**Alexandria Park
Community School**
7-11 Park Road, Alexandria

**Architectural
and
Urban Design**
Response to Submissions

Prepared for
NSW Department of Education

April 2018 | Issue C

3 WINTER 3PM
1 : 1000

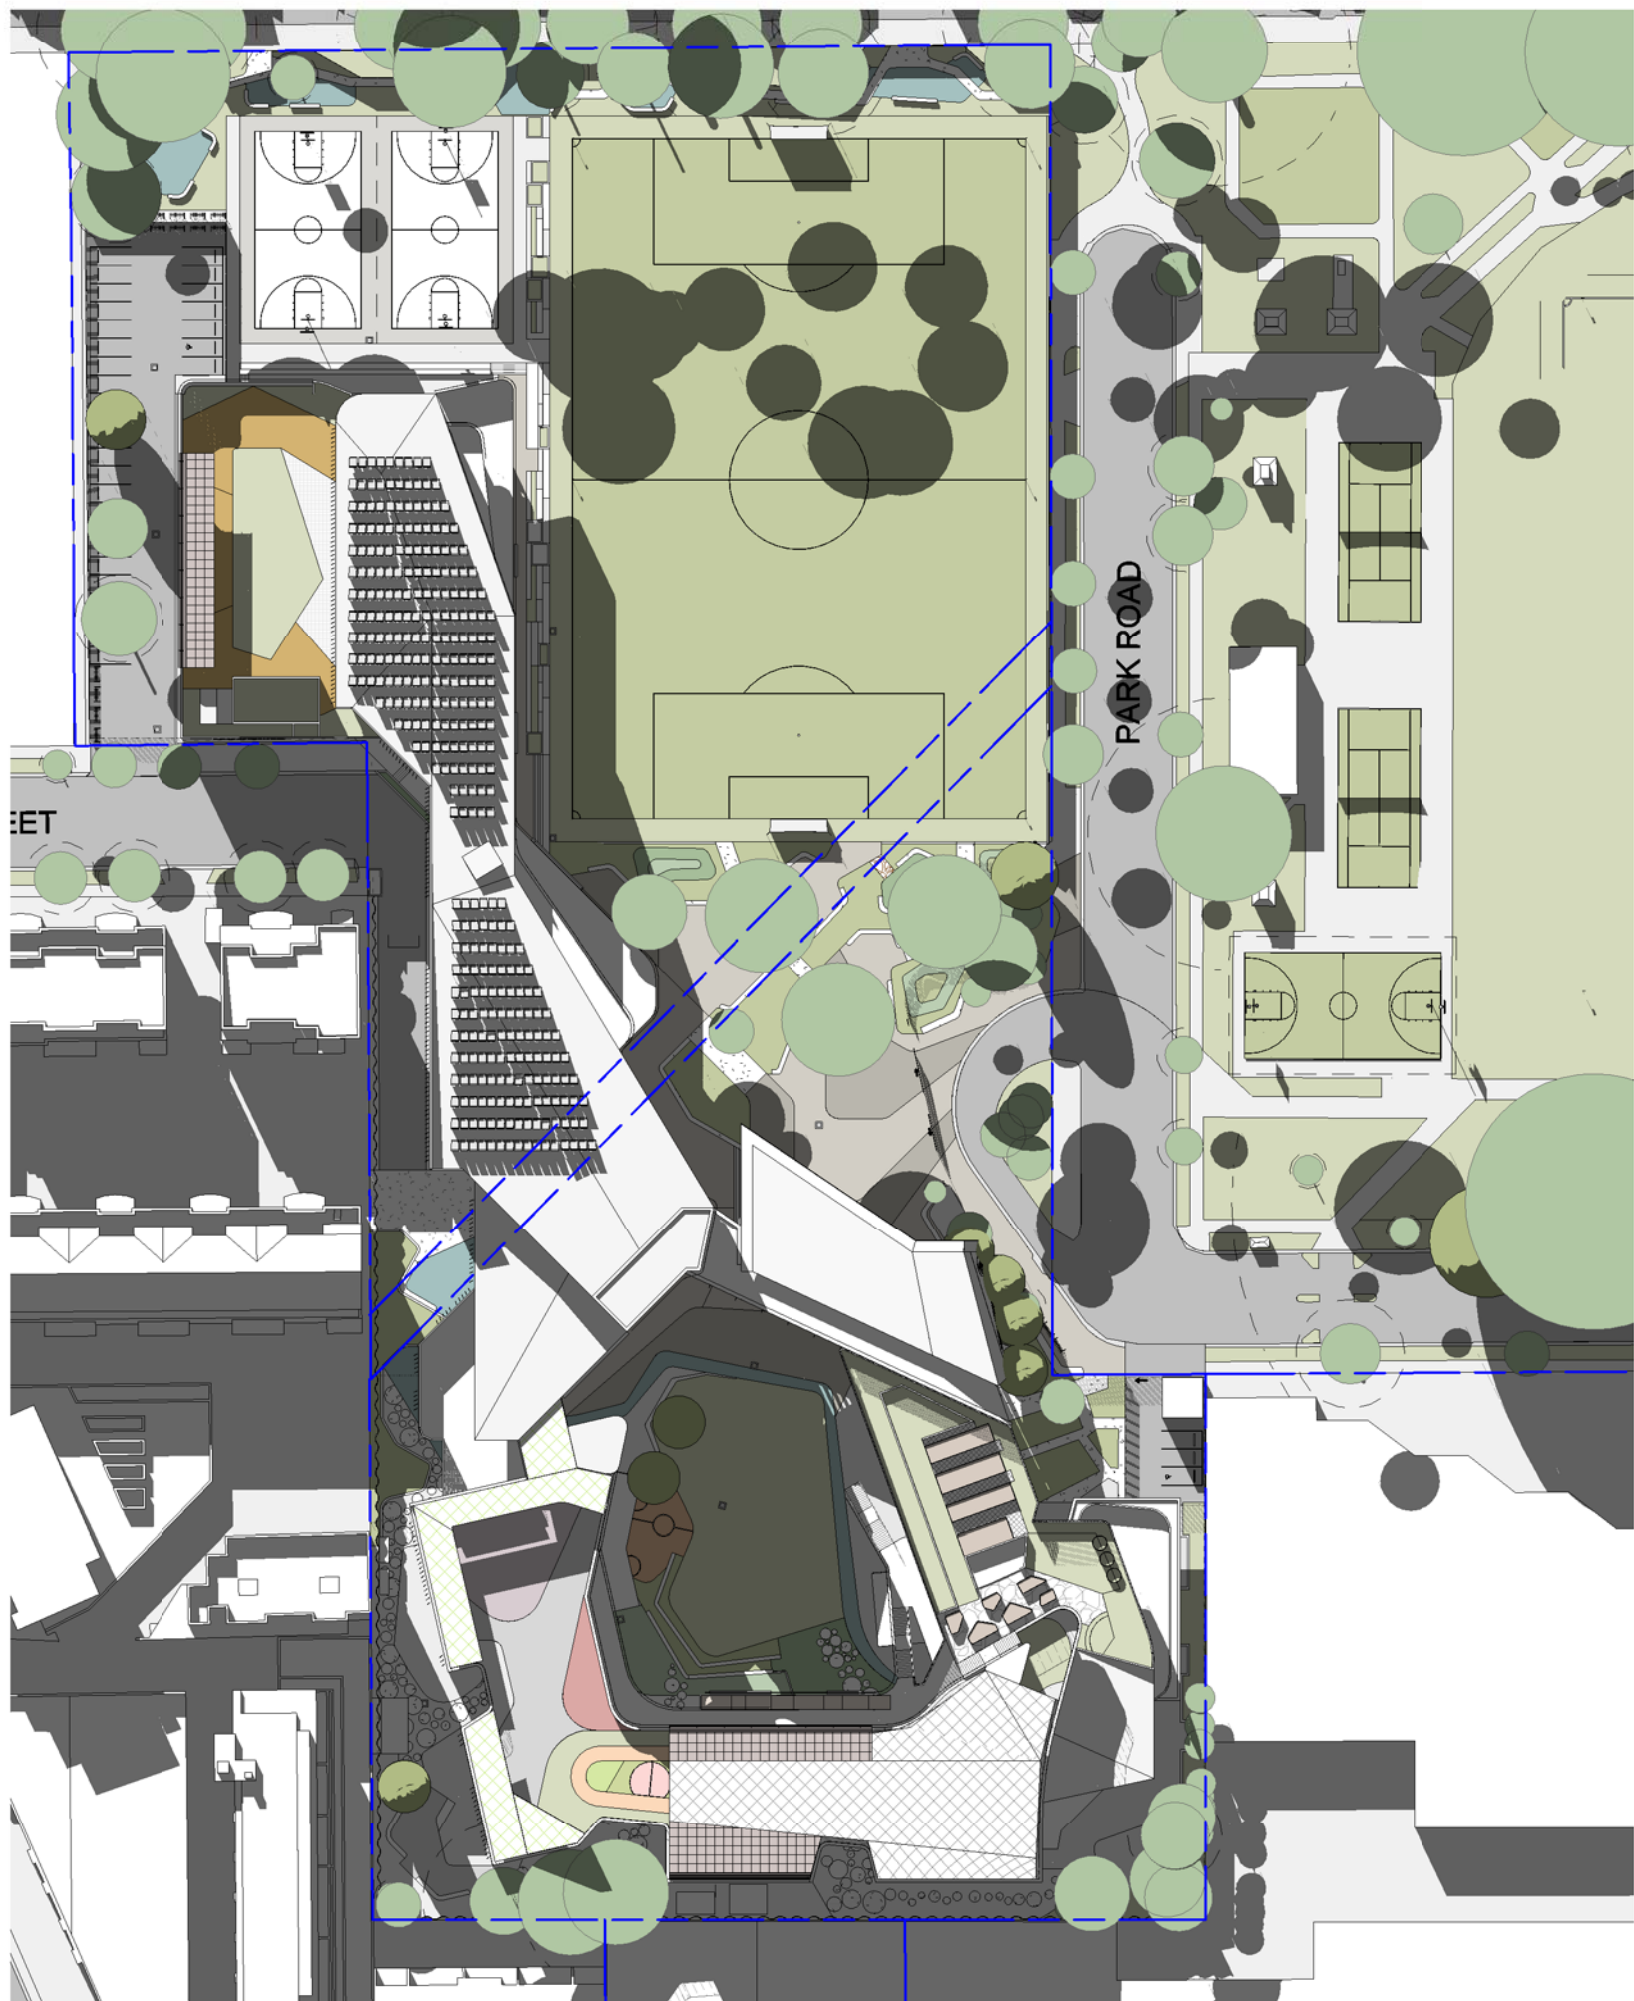
Further analysis of the shadow impact has focused on the residential developments to the west and south of the school. This analysis has reviewed the amount of solar access available to key living spaces of developments during the midwinter solstice and has compared existing (pre-redevelopment), as submitted, a notional 'complying height' development and amended development profiles should this be necessary. The two key residential developments are 58-60 Belmont Street and 141-143 McEvoy Street. The more detailed analysis has shown that these residential developments were affected to such a degree that the submitted design required modification to ensure that adequate solar access would continue to be provided each development. Other developments were not affected.

The proposed amendments involves shifting the gymnasium block and associated learning spaces 3m to the north and reducing the height of the gymnasium block along the edge facing Belmont Street. These two changes have greatly improved the solar access to apartments in this development as shown in the diagrams and views in the report.
